## **DUNGOG SHIRE COUNCIL**

### **SUBMISSION TO STATE SIGNIFICANT DEVELOPMENT 6612**

Dungog Shire Council has received an Environmental Impact Statement (EIS) prepared By Monteath & Powys on behalf of Buttai Gravel Pty Ltd, which is part of the Daracon Group, for the proposed consolidation and expansion of Martins Creek Quarry. The development has been lodged as a State Significant Application with the NSW Department of Planning and Environment, who will be the consent authority for the application.

Drawing Title
MARTINS CREEK QUARRY
DUKE STREET / KING STREET, PATERSON -
INTERSECTION MEDIAN WORKS

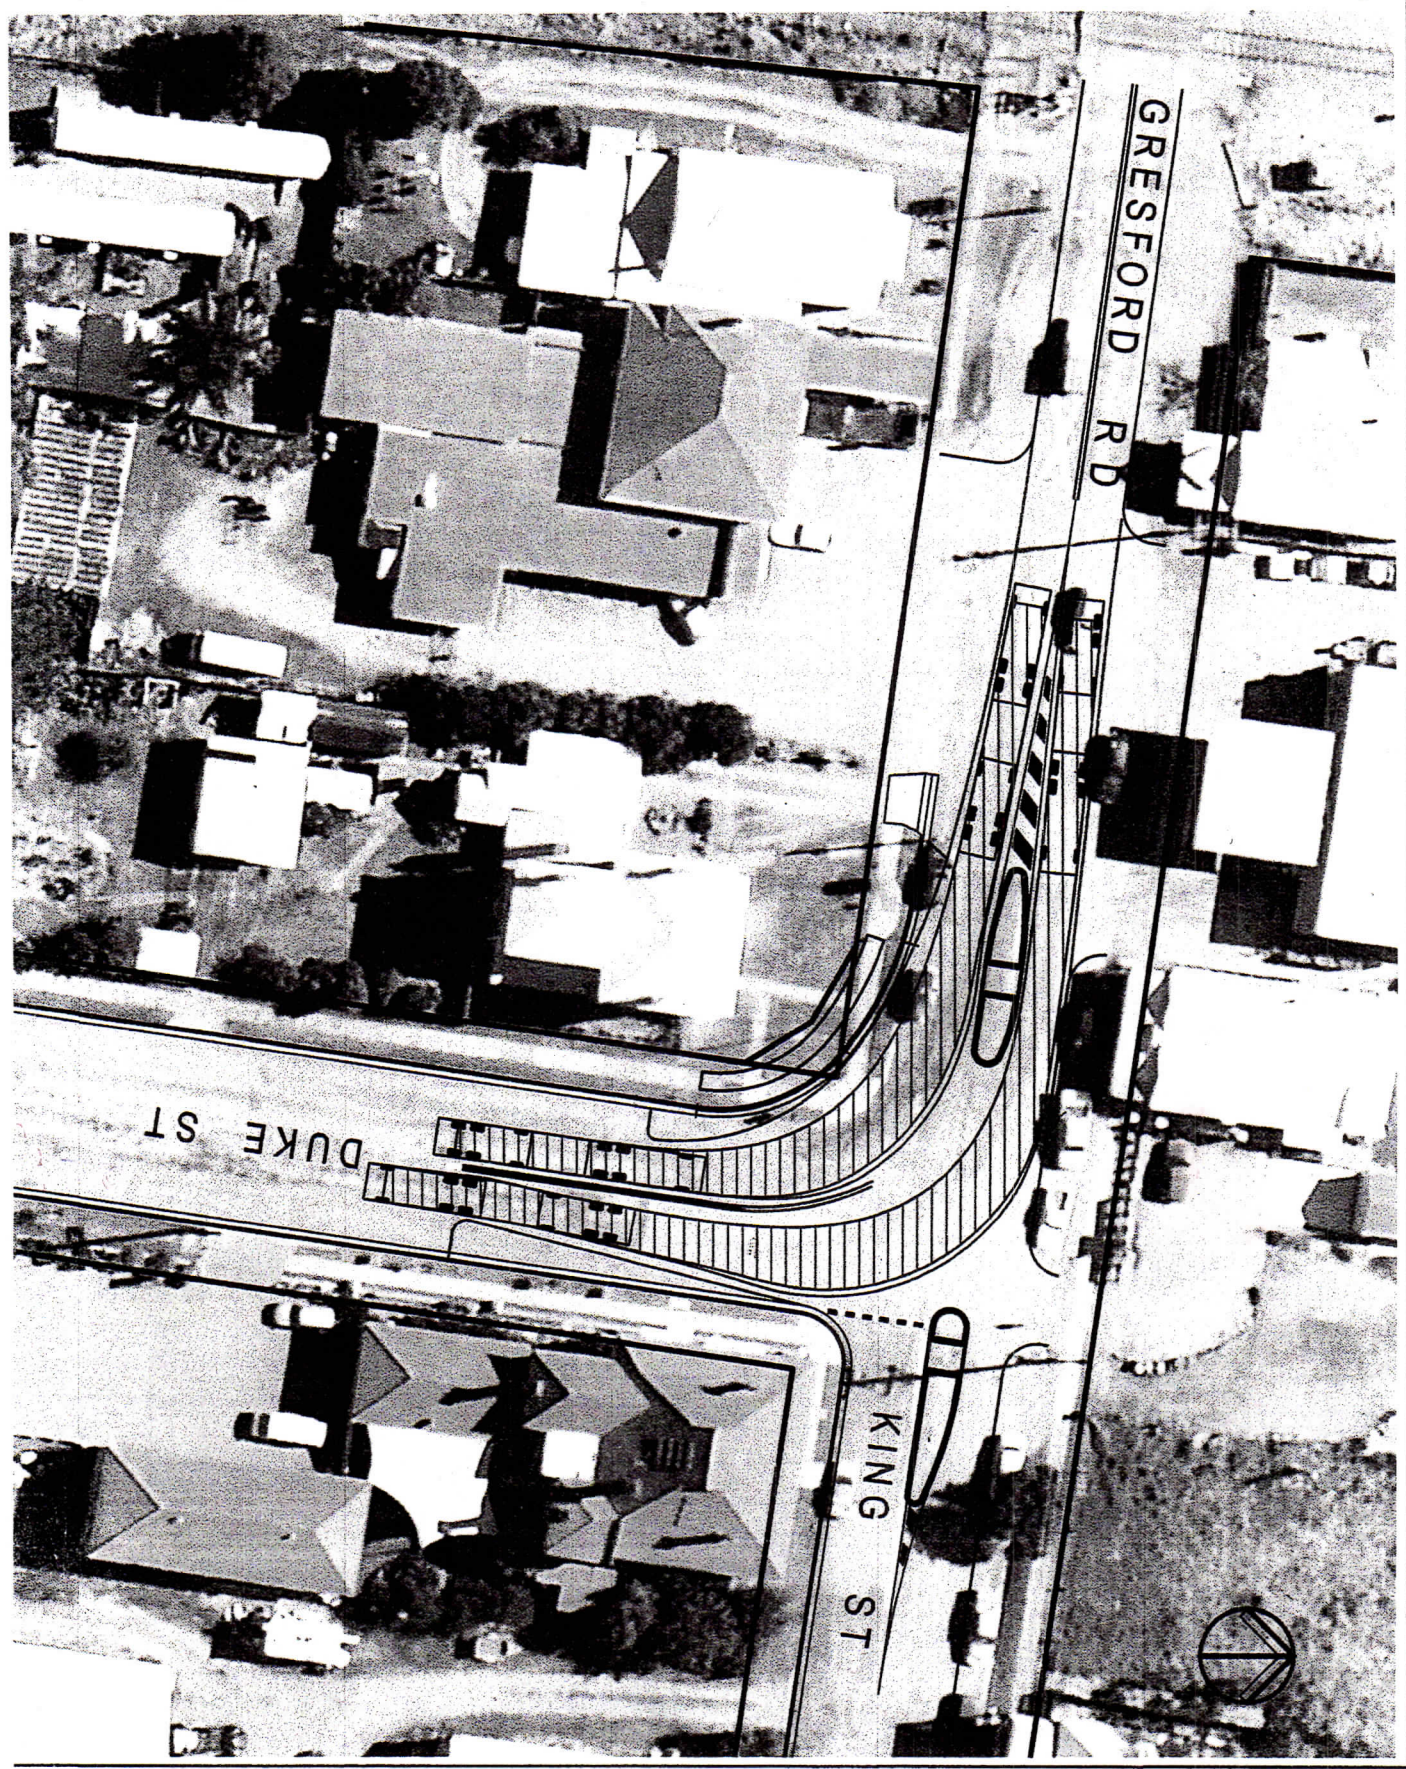
- On-street Parking Provision - Whilst the issue of on-street parking adjacent to the site has been identified, the report does not consider the loss of on-street parking within the Paterson Business Area as a result of the proposed intersection modification works at King and Duke Street.
